September 16, 1996

Martin J. Chávez, Mayor
Ronald Bohannan
Tierra West Development
4421 McCleod NE
Suite D
Albuquerque, NM 87109

RE: ROCKY MOUNTAIN R.V. (L22-D35) DRAINAGE REPORT SUBMITTAL FOR SITE DEVELOPMENT PLAN FOR SUBDIVISION APPROVAL, BUILDING PERMIT APPROVAL, AND GRADING PERMIT APPROVAL. ENGINEER'S STAMP DATED 9-13-96.

ENGINEER'S SEAL ROCKY MOUNTAIN RV-MARINE FACILITY GRADING AND DRAINAGE PLAN 12,700 CENTRAL S.E. ALBUQUERQUE, NM 87123	DRAWN BY: Pvg DATE: 6-22-94 9412GR.DWG SHEET #
	TERRA WEST DEVELOPMENT MANAGEMENT SERVICES 4421 McLEOD ROAD, NE SUITE D ALBUQUERQUE, NEW MEXICO 87109 (505)883-7592	JOB # 940012

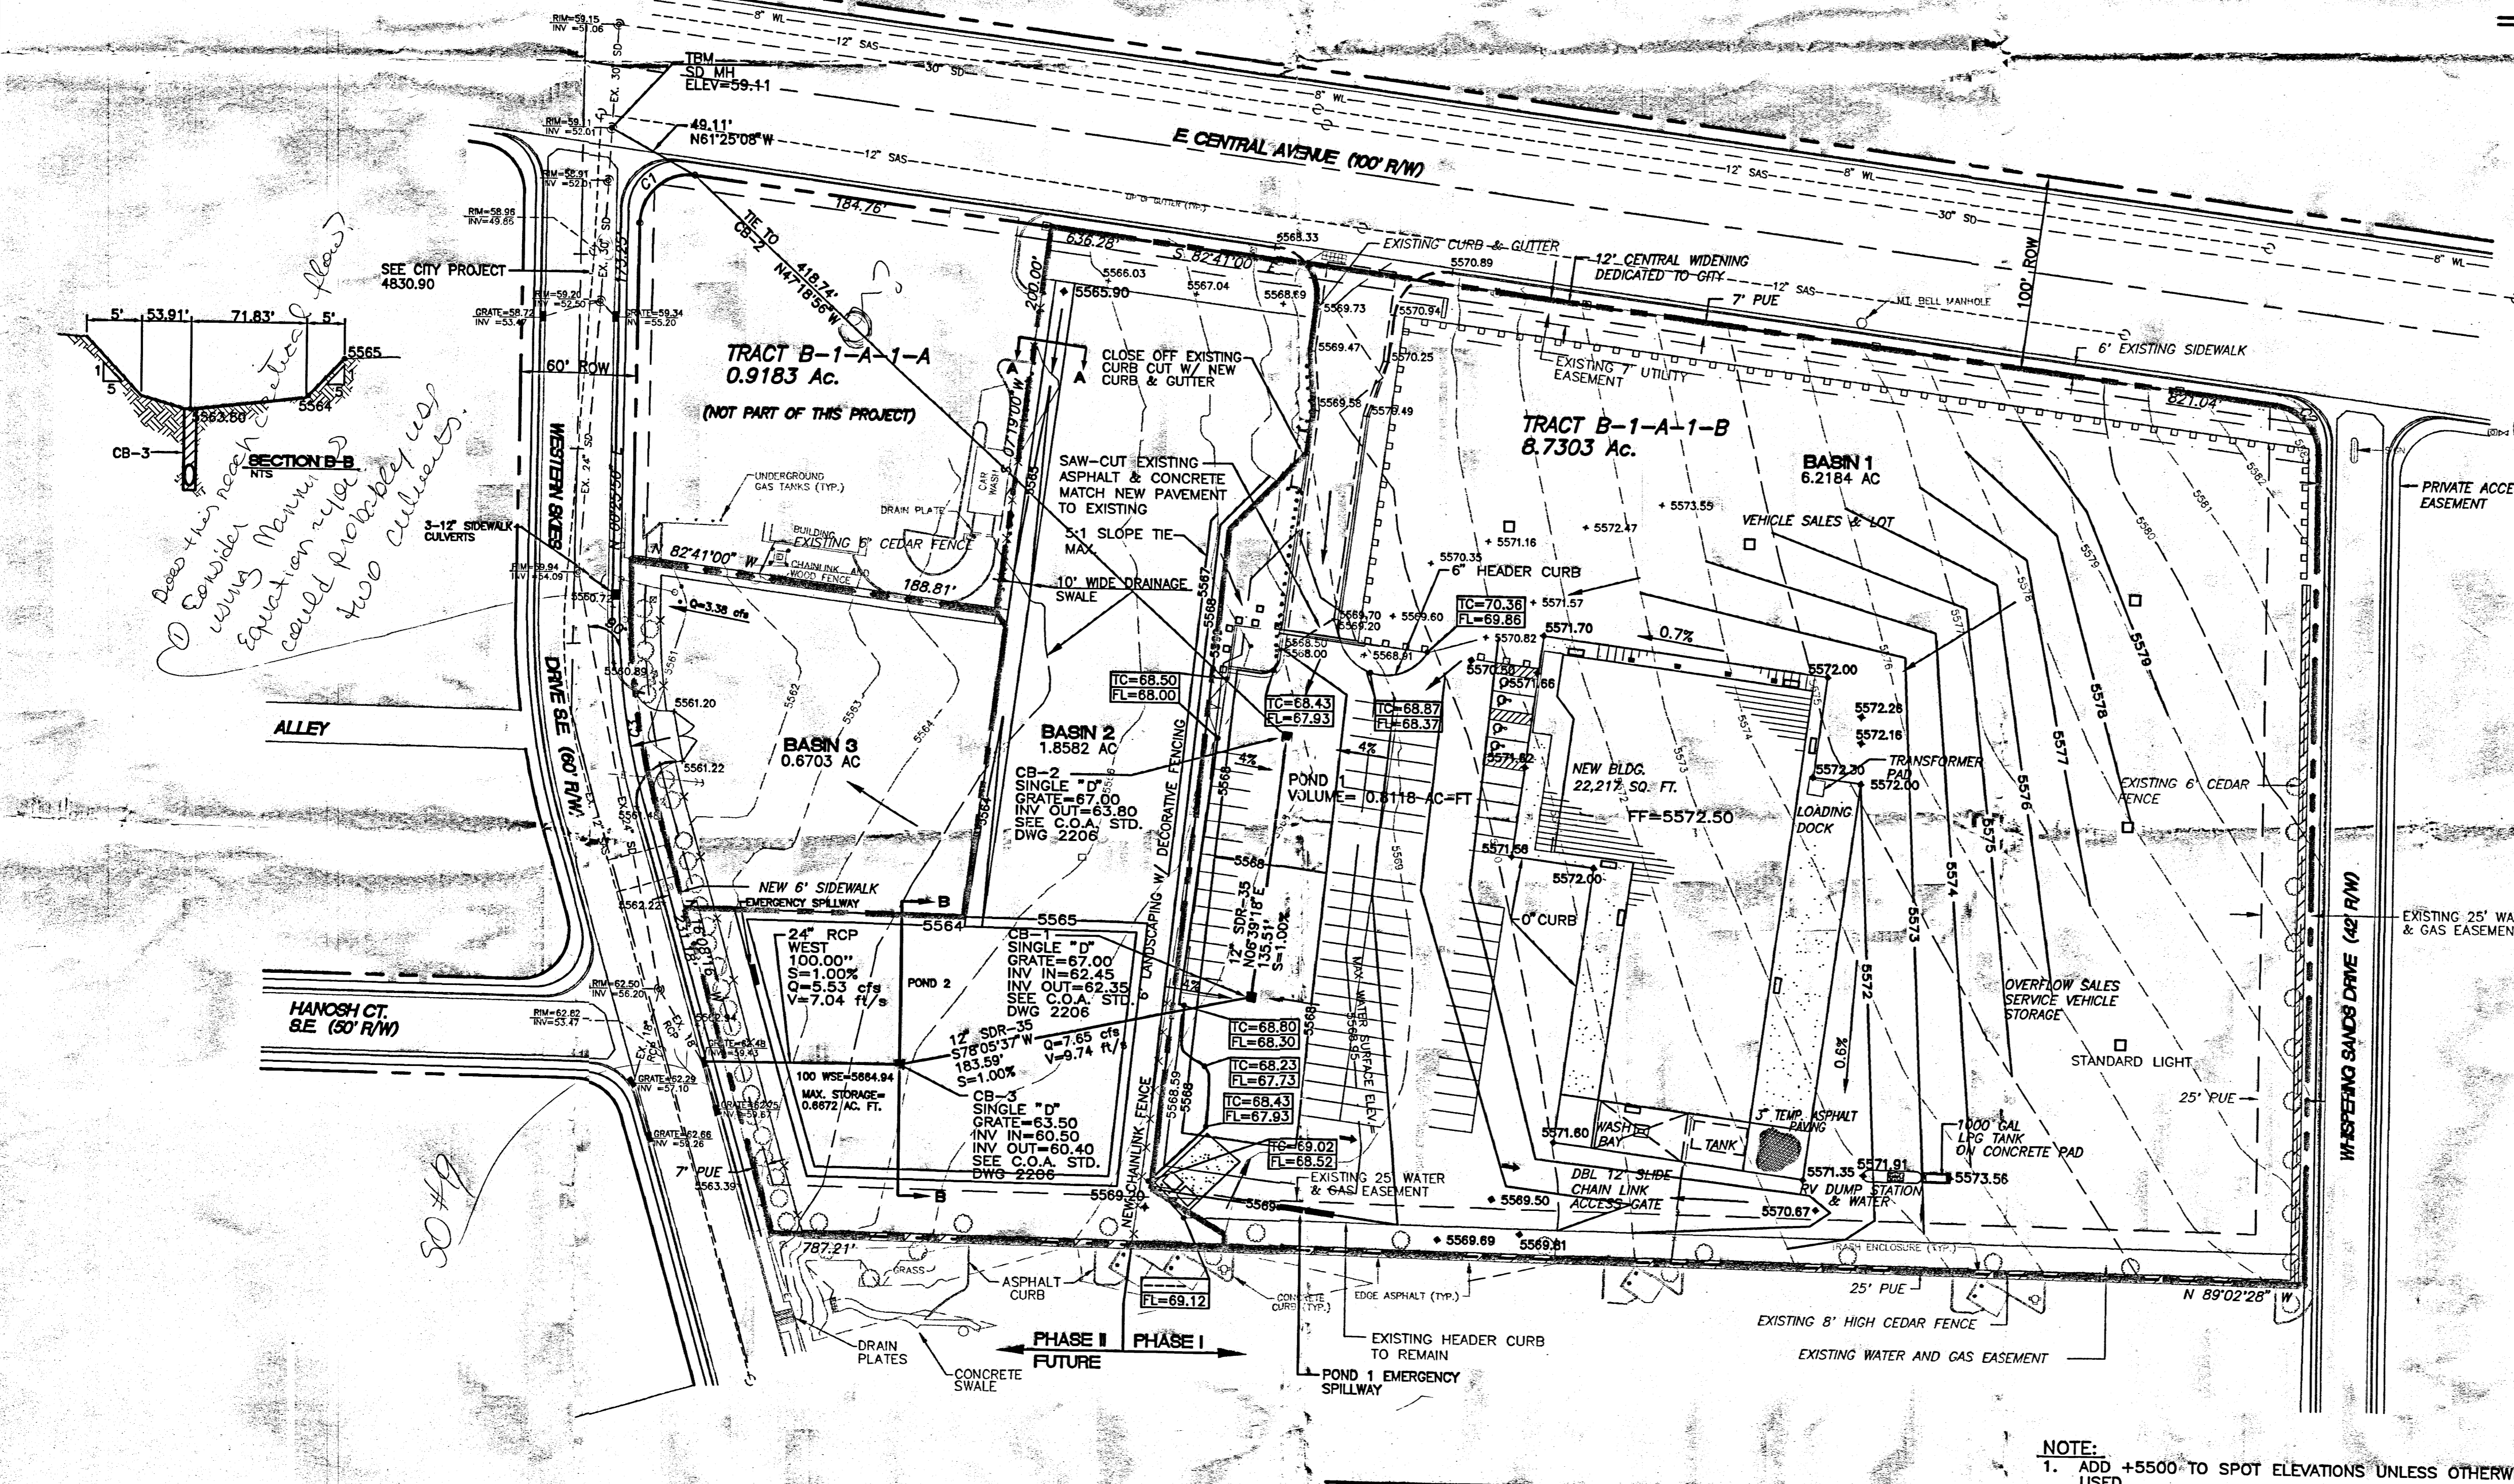
1. An SO #19 Permit is required for this project due to the work proposed in the right-of-way. Please be certain to show the required notes and sign-off block on the plan sheet. Also, provide two copies of the Grading and Drainage plan.
2. Shown on your plan sheet is a distance and bearing line from catch basin 2 to the corner of Western Skies and Central. Please change the line type. It looks very similar to a storm drain line.
3. If you desire, you can use an 12-inch pipe with a 10-inch orifice to tie into the back of the existing inlet on Western Skies.
4. Are your sidewalk culverts in a submerged condition? If not, I believe you can get away with using two sidewalk culverts instead of three
